**Consultation Response from KC,
Highways Development Management**

2024/93158 23, Victory Avenue, Paddock, Huddersfield, HD3 4HA

Erection of two storey side and rear extensions, front and rear dormers and creation of raised patio to rear including associated works

Date Responded: 11-12-2024.

3 Site Plan
1 : 200

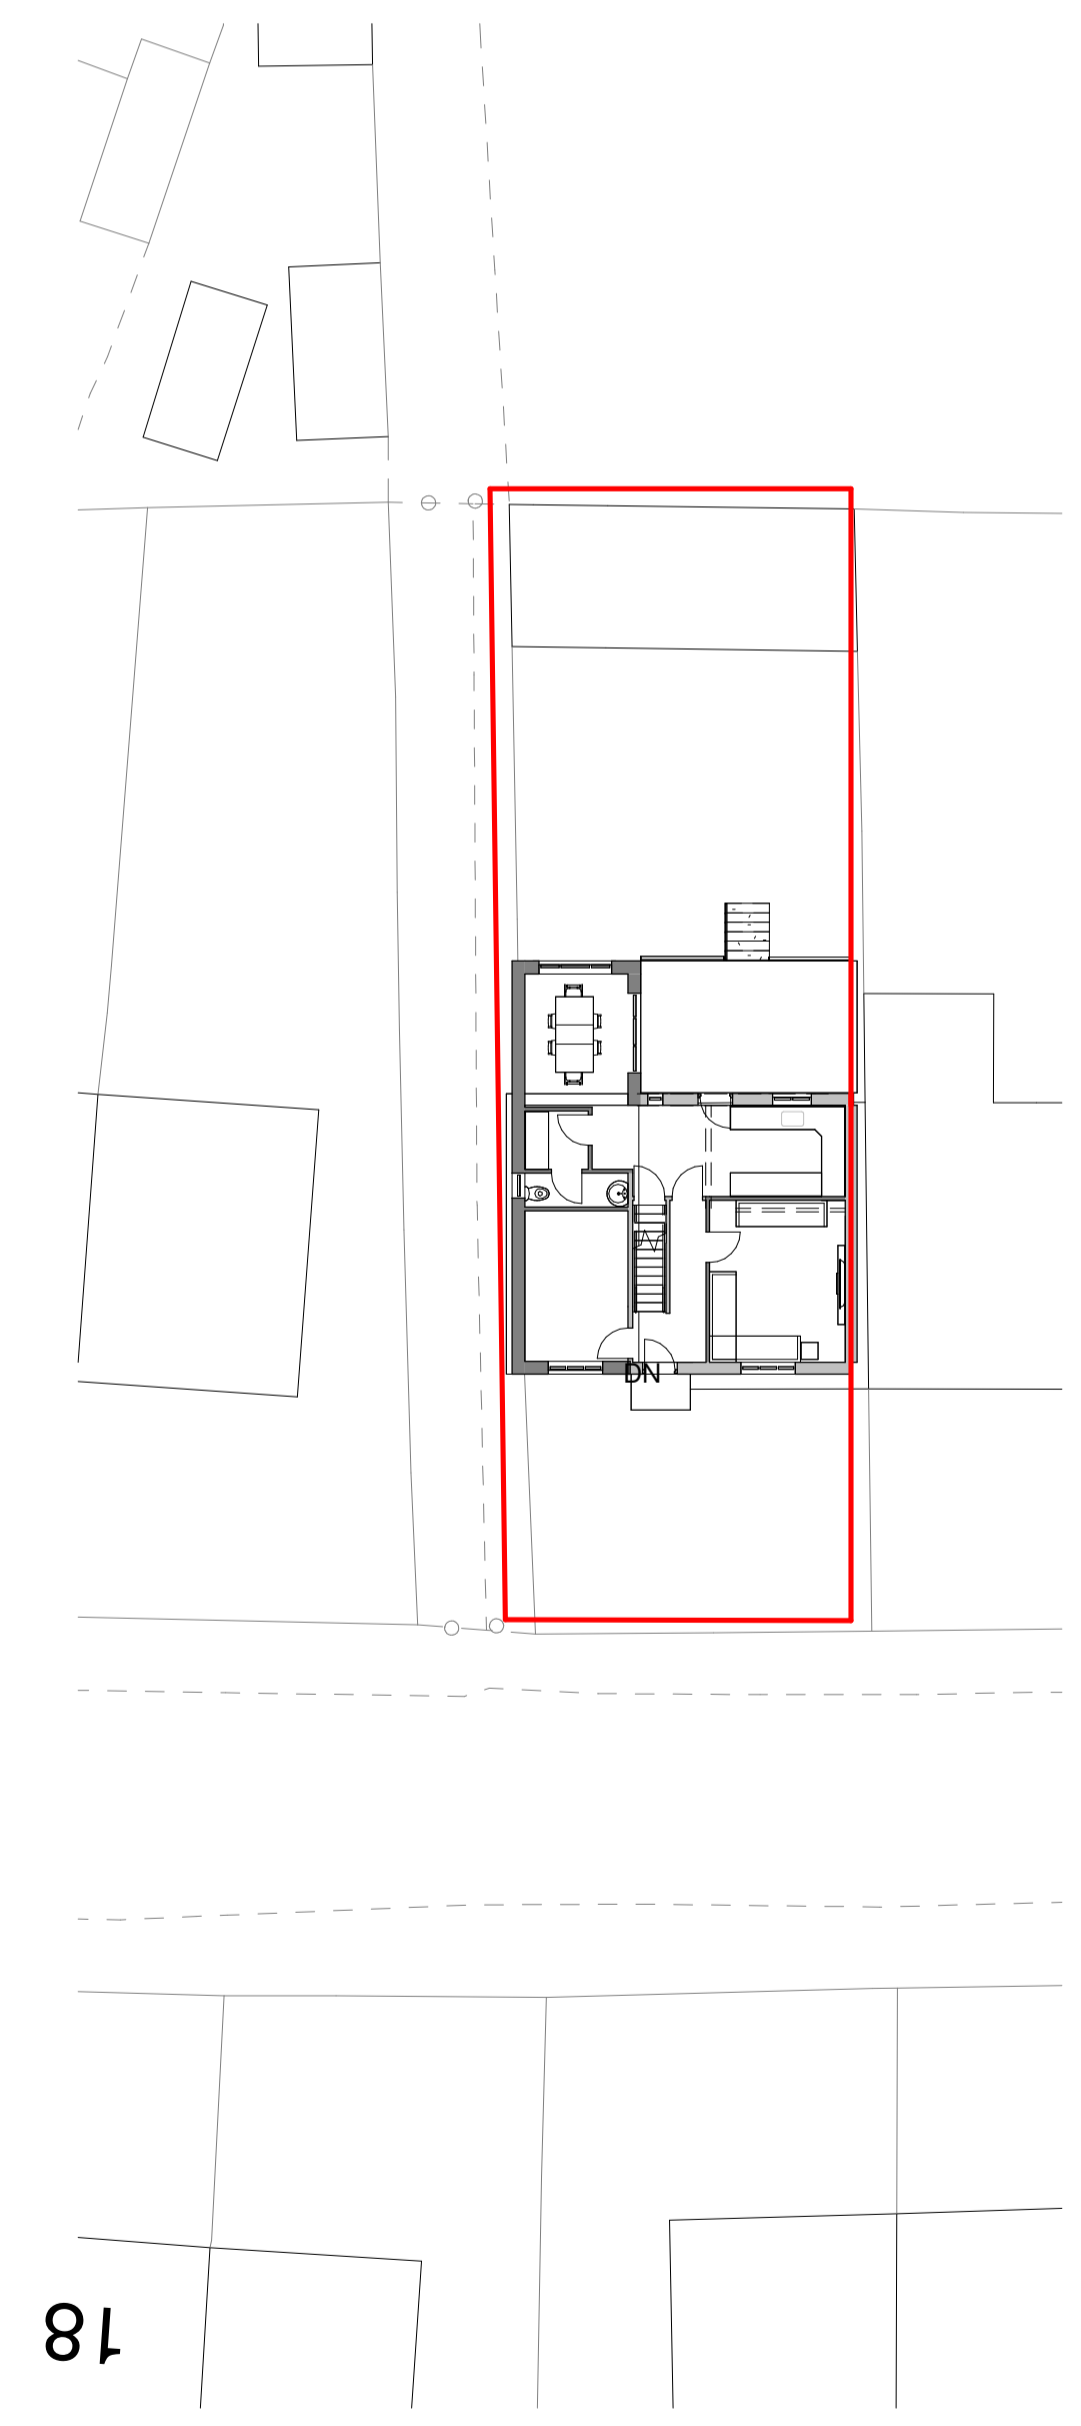
This proposal results in the conversion of a 3 bed roomed house to a 5 bed roomed house and the loss of existing off-street parking to the side.

Highways Development Management would therefore recommend that additional off-street parking is shown to be provided to the frontage of the site.
